Yorkshire Water Services  
Developer Services  
Pre Development Team  
PO BOX 52  
Bradford  
BD3 7AY

Your Ref: 2020/92067  
Our Ref: W011099

**Former Stile Common Infant & Nursery School, Plane Street, Newsome, Huddersfield - Erection of 30 dwellings**

Job No.
1375/02

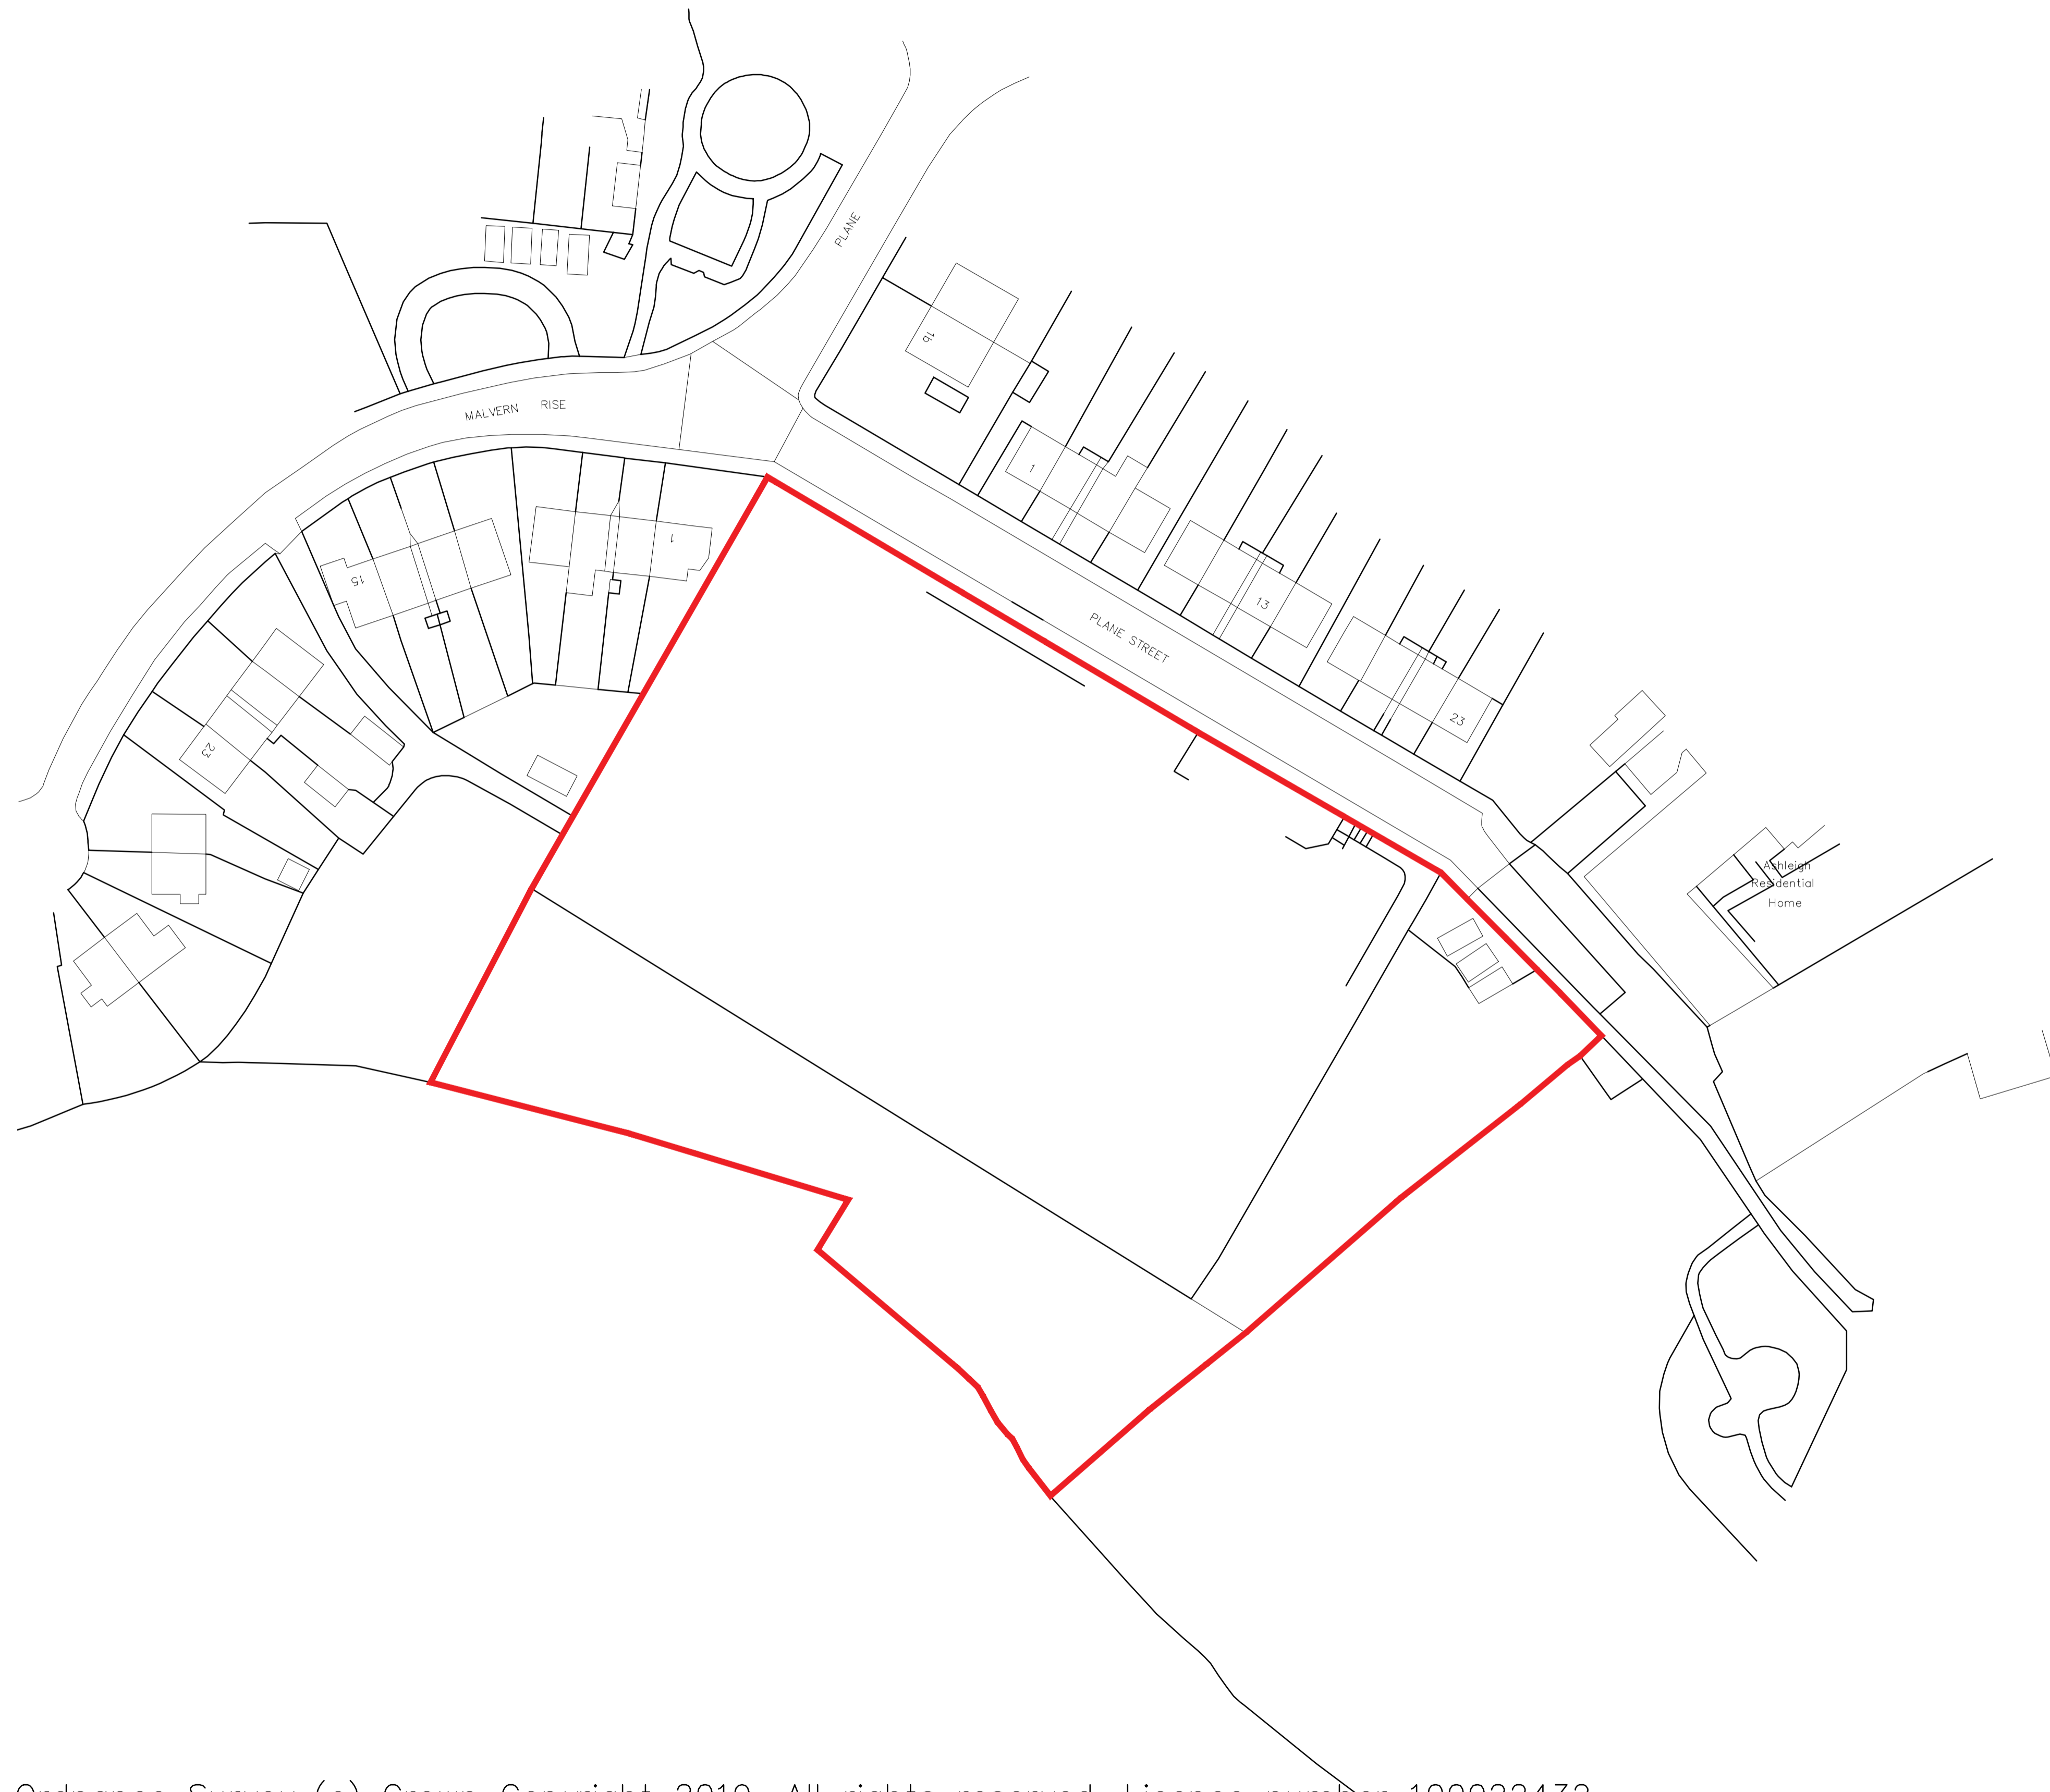
1) The submitted drawing no. 2375/02/05 dated 29.06.20, prepared by ARP Associates is acceptable. We have no objection to:

- i) the proposed separate systems of drainage on site and off site;
- ii) the proposed point of discharge of foul water to the 225mm diameter public combined sewer located in Plane Street; and
- iii) it is noted that the submitted drawing shows surface water proposed to be drained to a culvert located along Newsome Road to the east of the site at a rate of 5 (five) litres per second.
